David Mooney - Erskine Park Milk Processing Facility - EIS

Erskine Park Milk Processing Facility (SSD-6026) Response to exhibition of Environmental Impact Statement

Attachment A
Erskine Park Milk Processing Facility (SSD-6026)
Response to exhibition of EIS
Comment by NSW Office of Water

Appendix 1: Site Drainage Layout

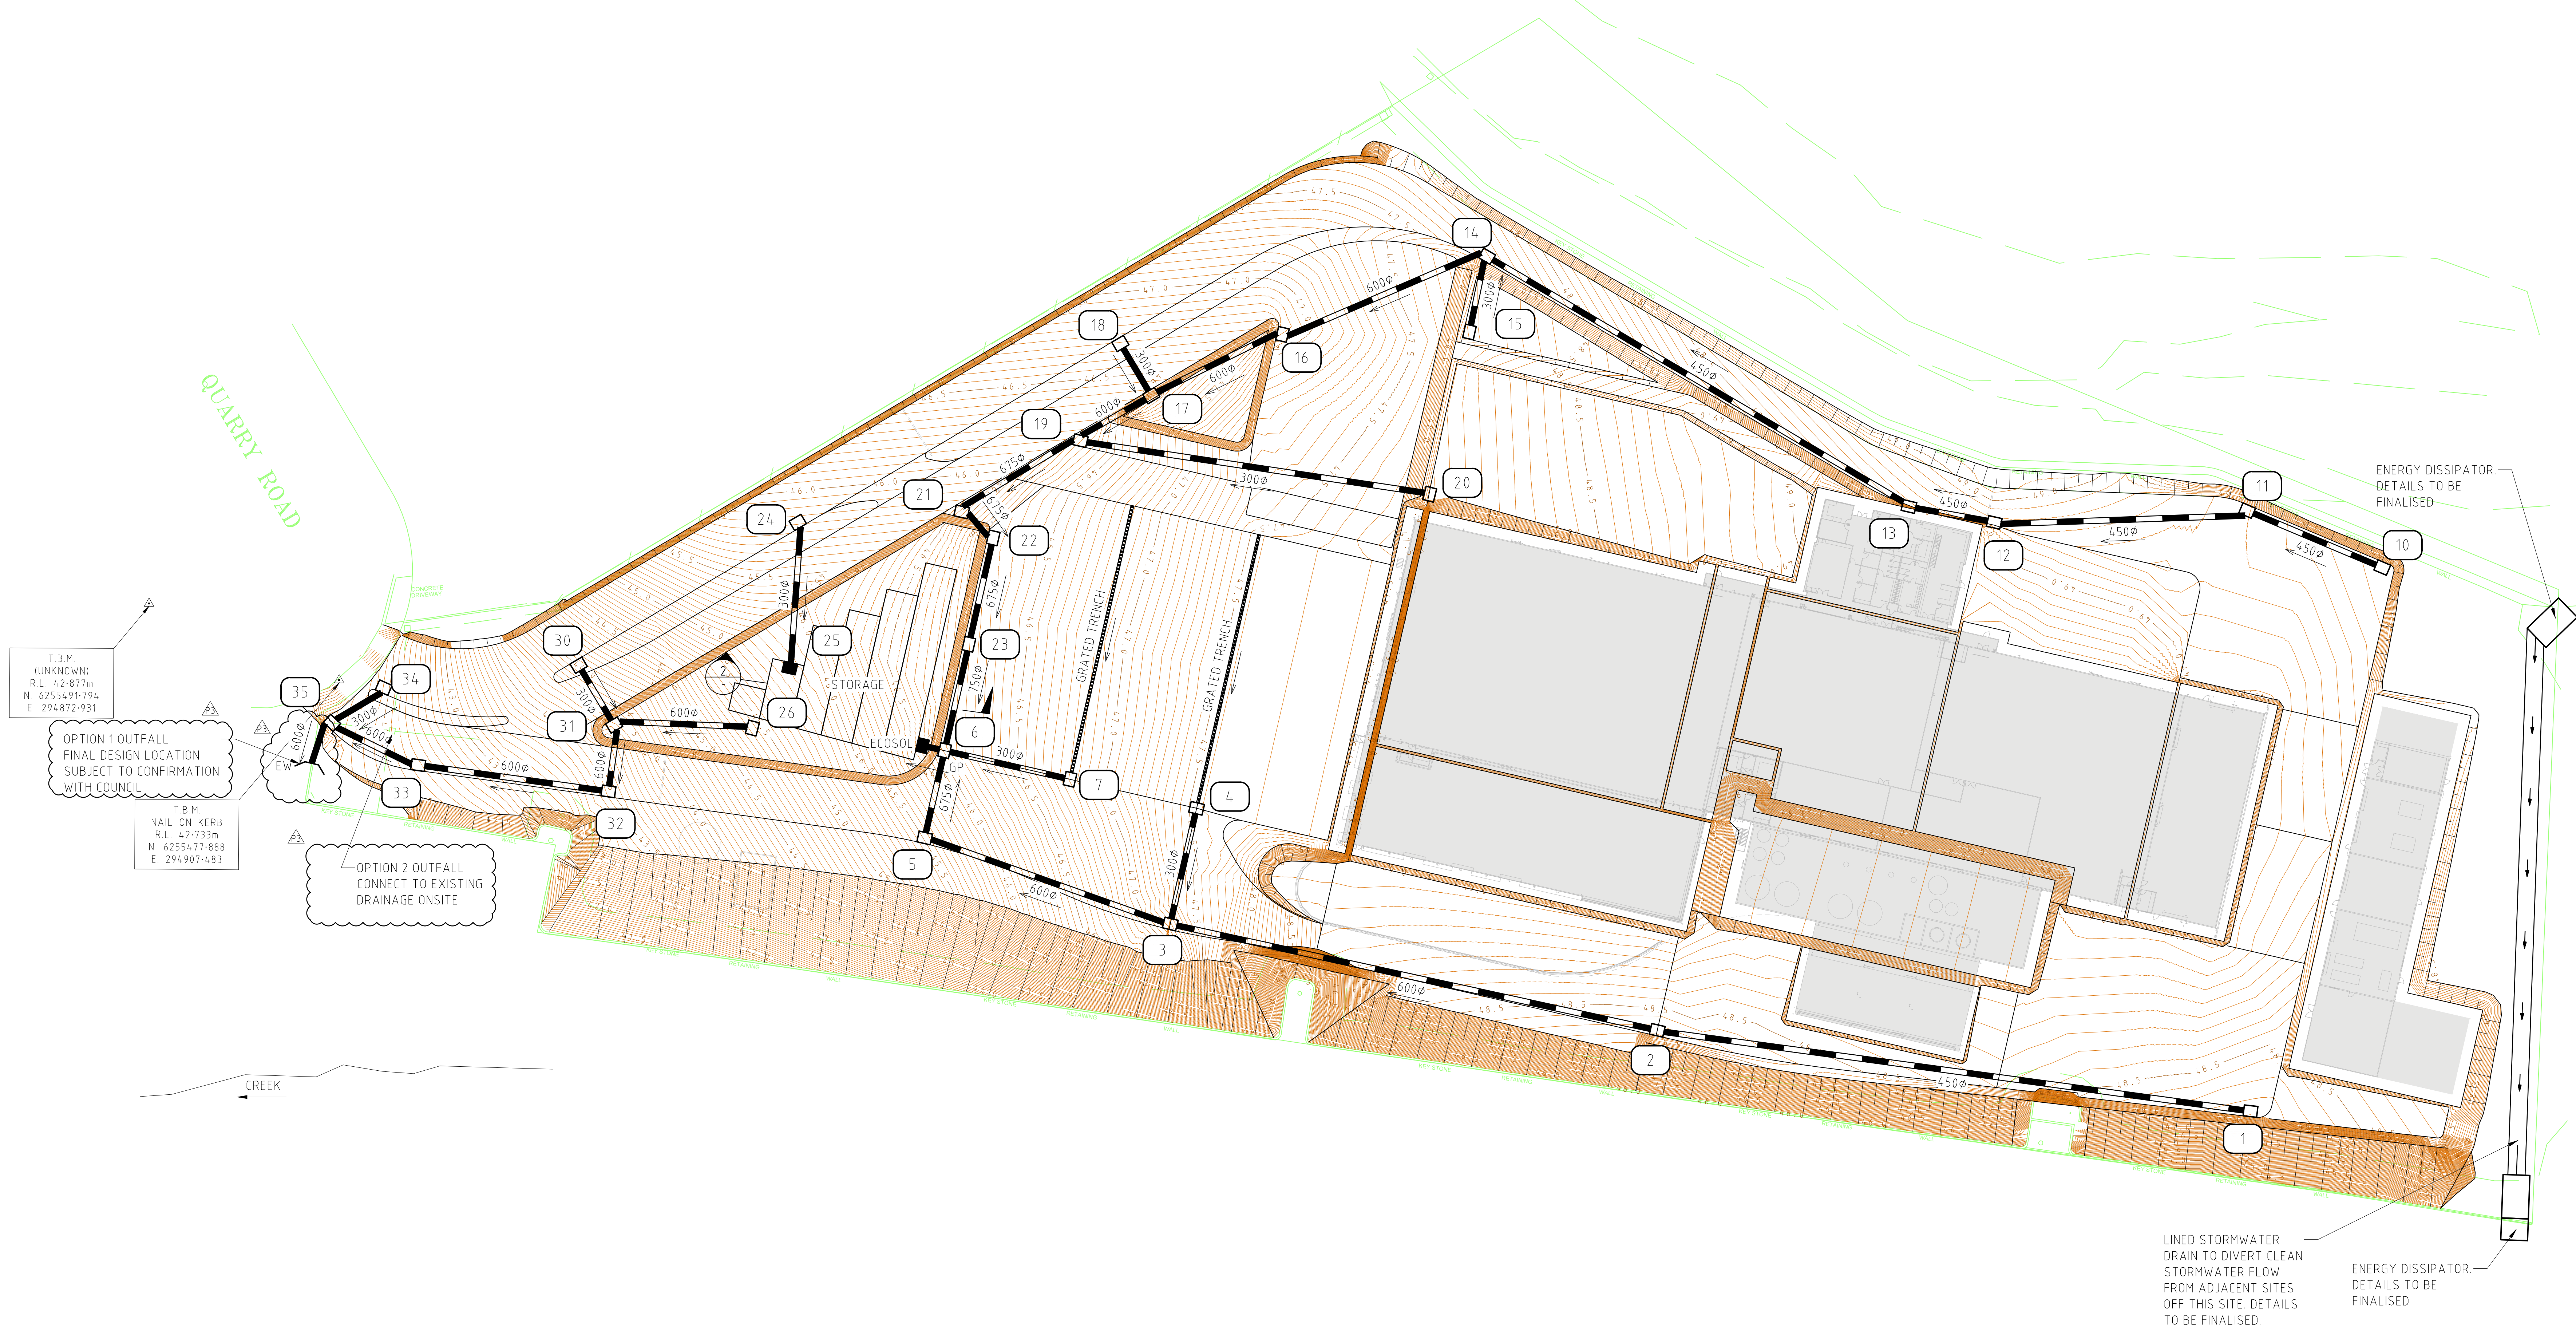
Technical Paper TP10c recommends that an impermeable liner should be installed at the base and walls of the basins to minimise water logging, infiltration and potential recharge of the underlying perched aquifer (page 24). Details are required on the proposed depth of the temporary detention basins to determine if the basins are likely to intercept groundwater.

DETAIL
1:400

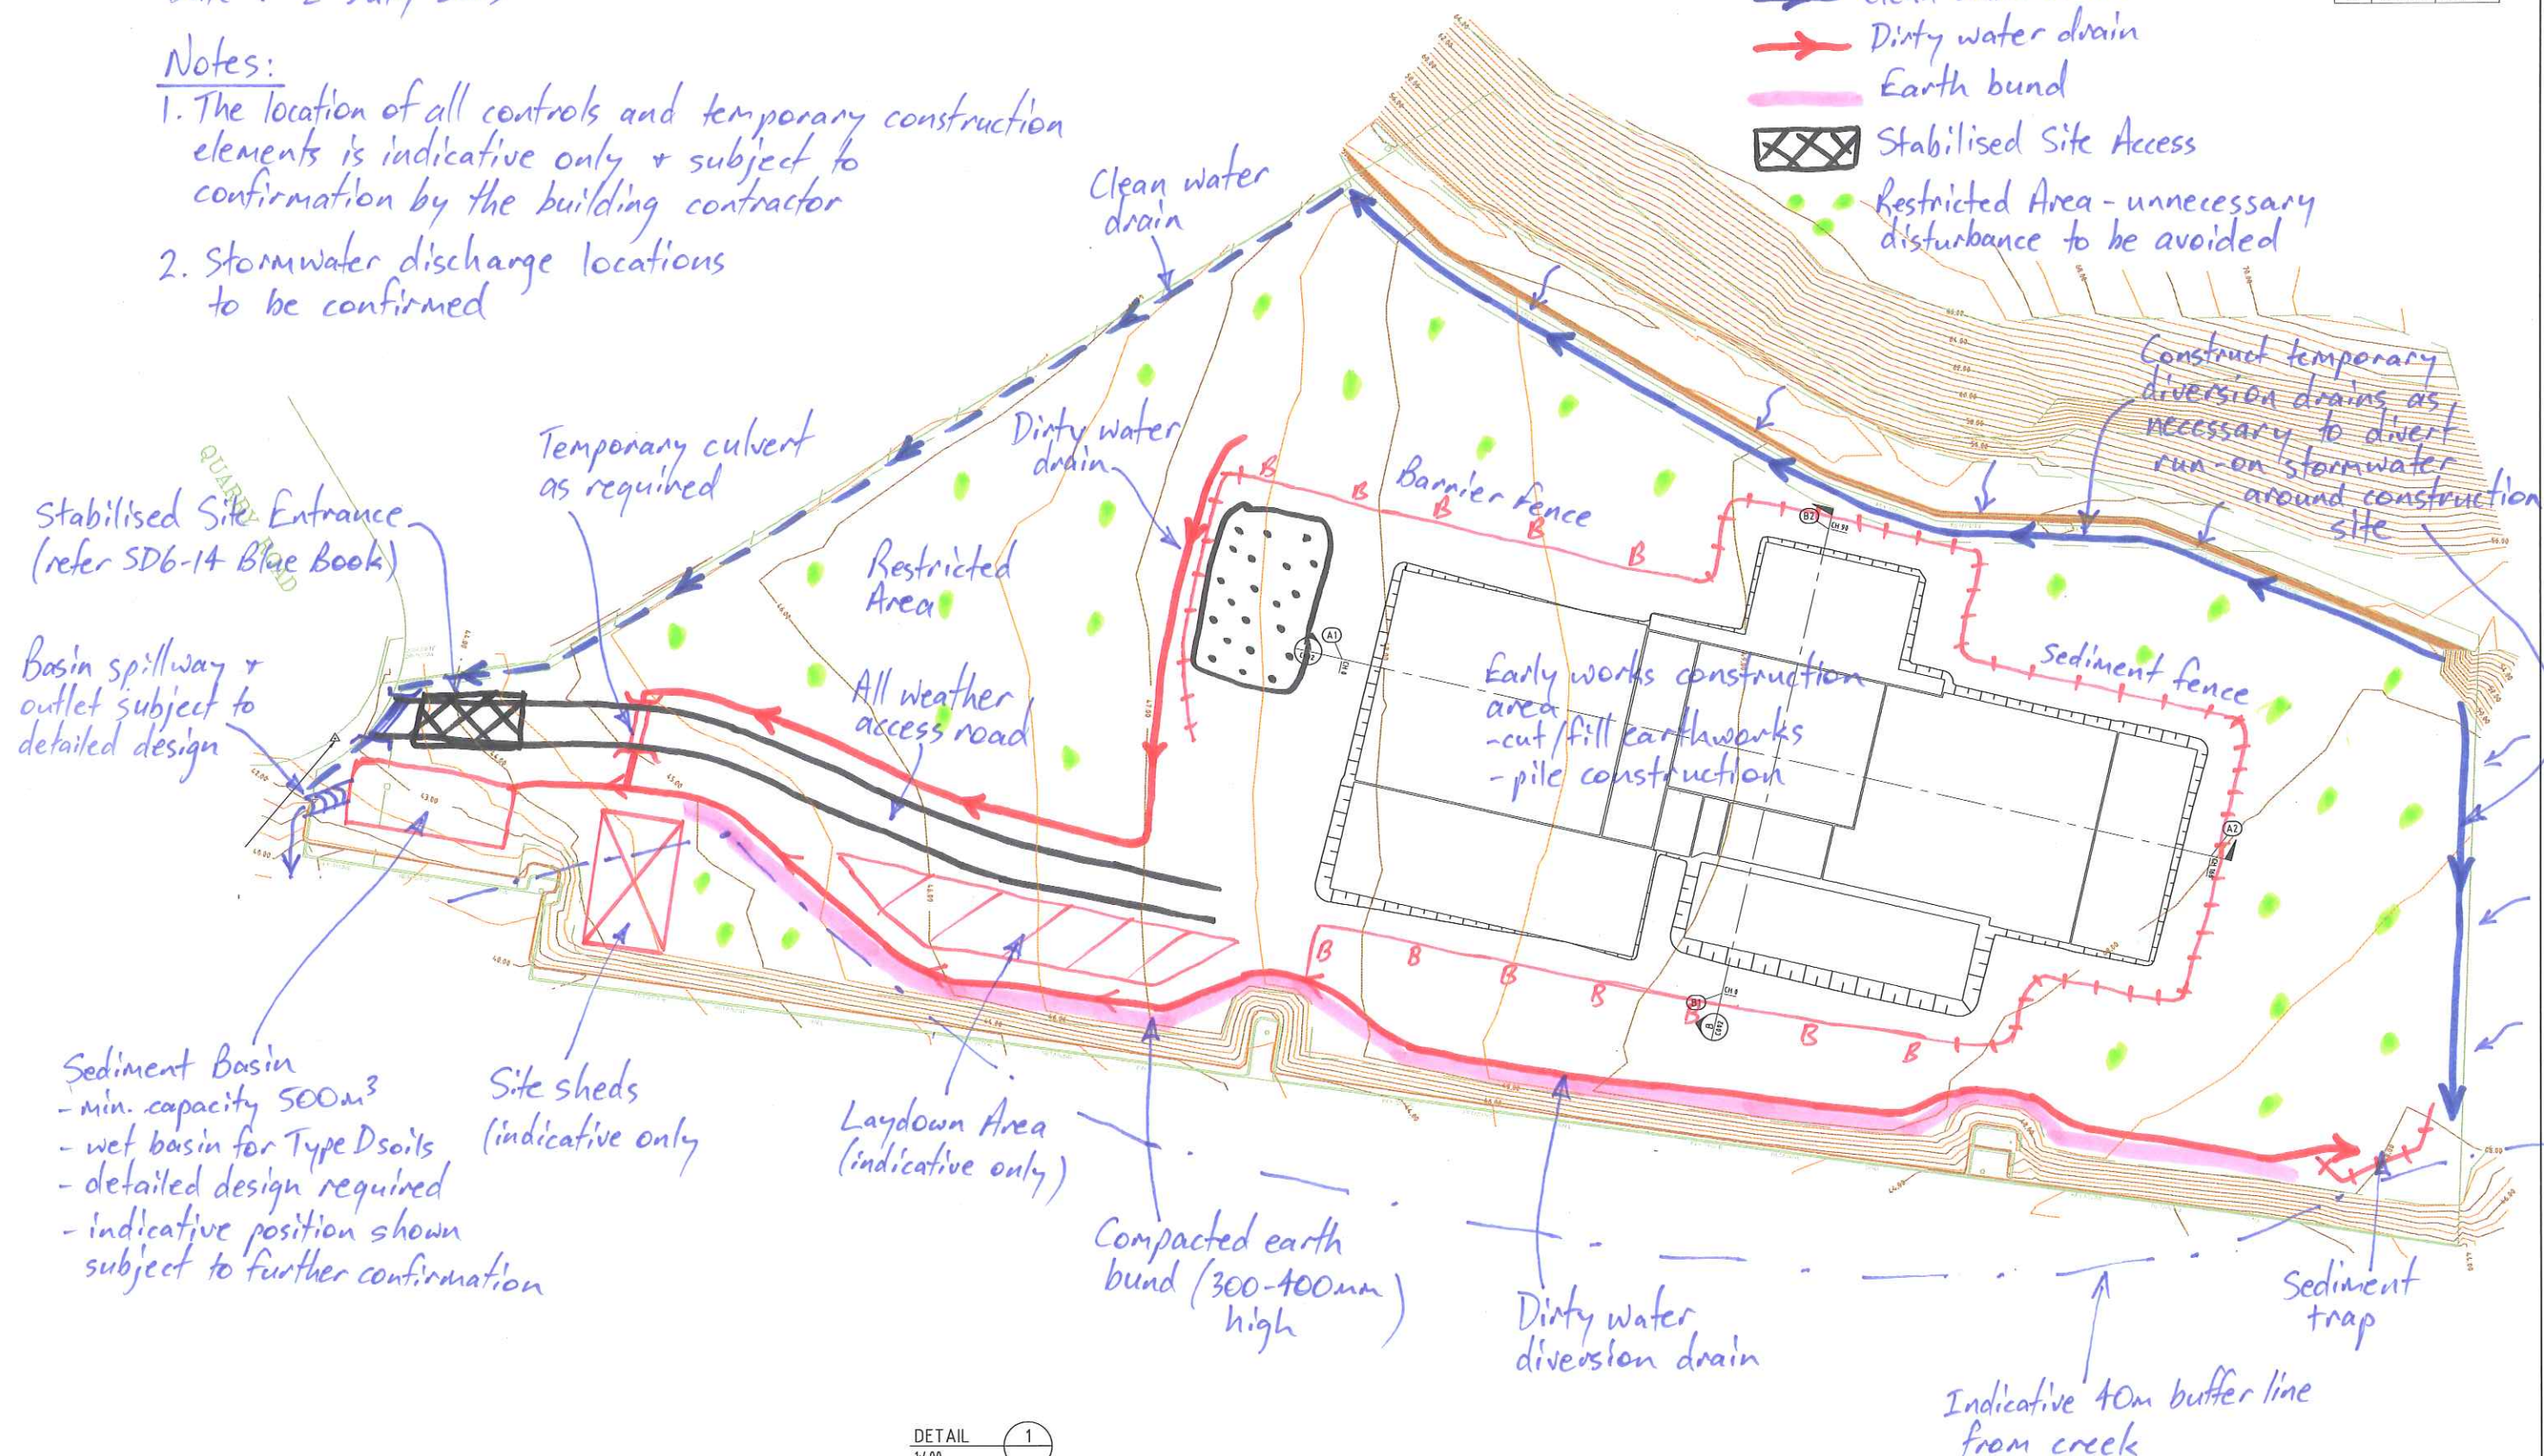
Appendix 3 of Technical Paper TP3 notes the stormwater outlet location is within cleared lands and River-Flat Eucalypt Forest (page 34). The Office of Water recommends the following:

- the stormwater outlet structure be placed to avoid disturbing remnant native vegetation; and
- a scaled plan is provided which shows the location of:
 - the proposed stormwater structure route
 - the creek and top of bank
 - the boundary of the biodiversity/riparian corridor
 - remnant native vegetation potentially affected by the outlet structure.

Technical Paper TP6c states there are two potential discharge locations for the stormwater outlets in the south east and south west and in both locations stormwater may need to be conveyed down relatively steep gradients and appropriate grade control structures would be required (page 12). The Office of Water agrees that the works should be designed to discharge stormwater in suitable locations at non-erosive velocities that will not cause damage to the receiving environment. As far as practicable, the works should be kept outside the 40m buffer surrounding the creek.
